Our Ref: P/2/22/DOC

Approval of details reserved by condition imposed under P/10/20/PL relating to conditions 3-internal noise levels, 6-covered & secure cycle parking; 7-electric vehicle charging & 8-storage of waste.

The Pagham Club 2 West Front Road Pagham PO21 4SY

Block Plan REV02

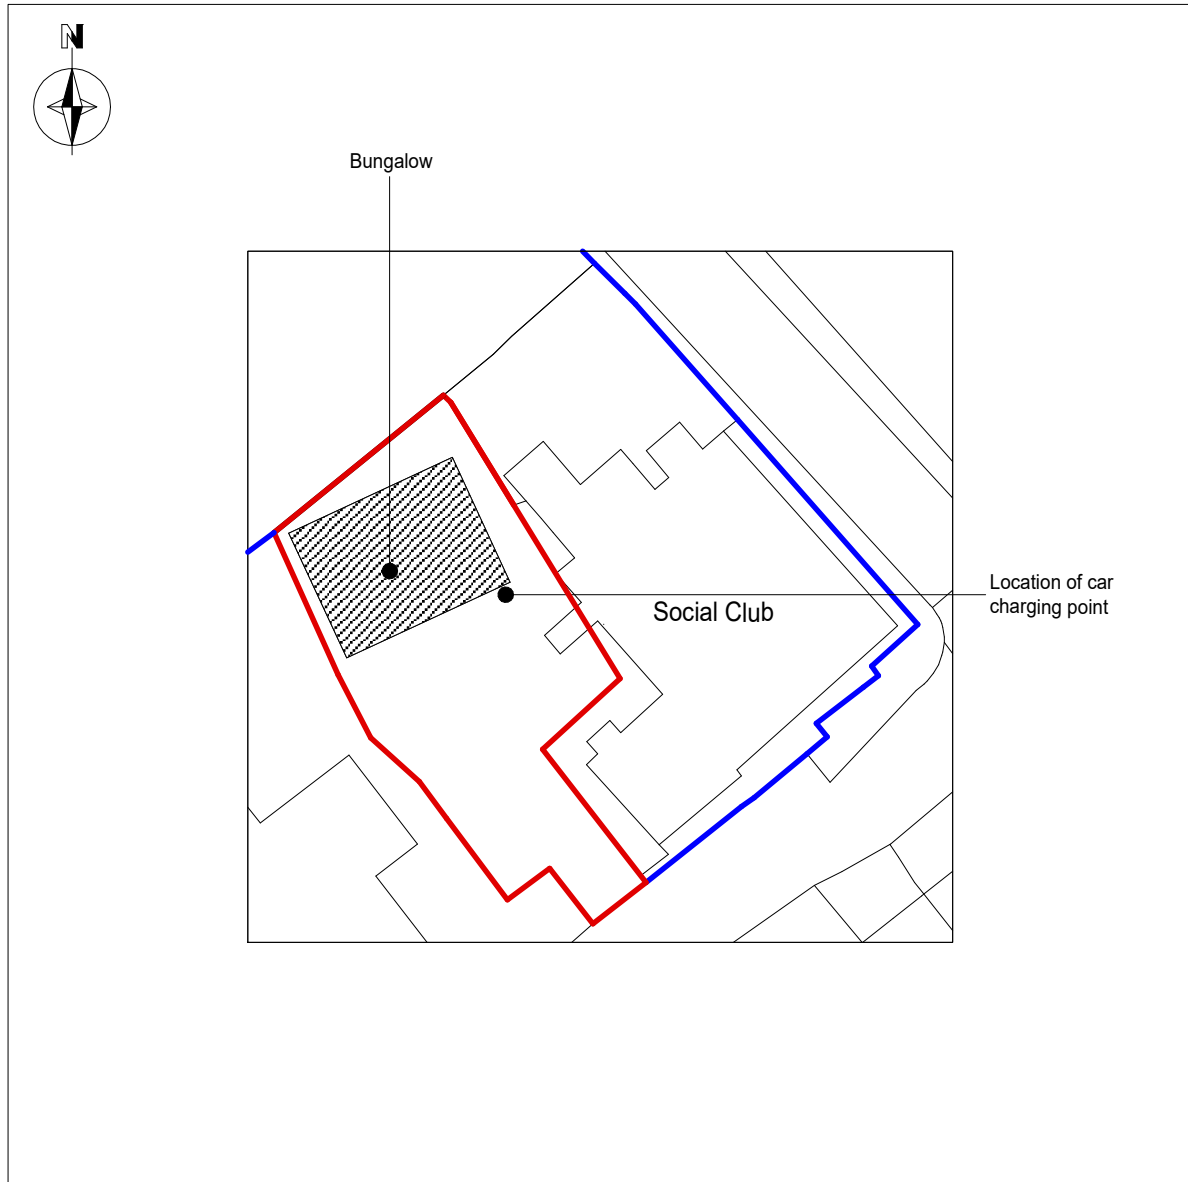
"The photographs show that a cycle storage area has been provided for the unit providing storage for up to 3 cycles in a partially covered 'butterfly stand' arrangement. The LHA would ideally like to see open-fronted cycle storage areas being provided with Sheffield stands and fully covered. Alternatively cycle provision can be provided within a secure lockable building such as a shed. The LPA are advised to consider whether the proposed demonstrated cycle storage fully satisfies the above condition."

Whilst the cycle storage is partially open, it is located towards the rear of the site and is acceptable provision for its use serving one residential unit and the condition can be discharged.
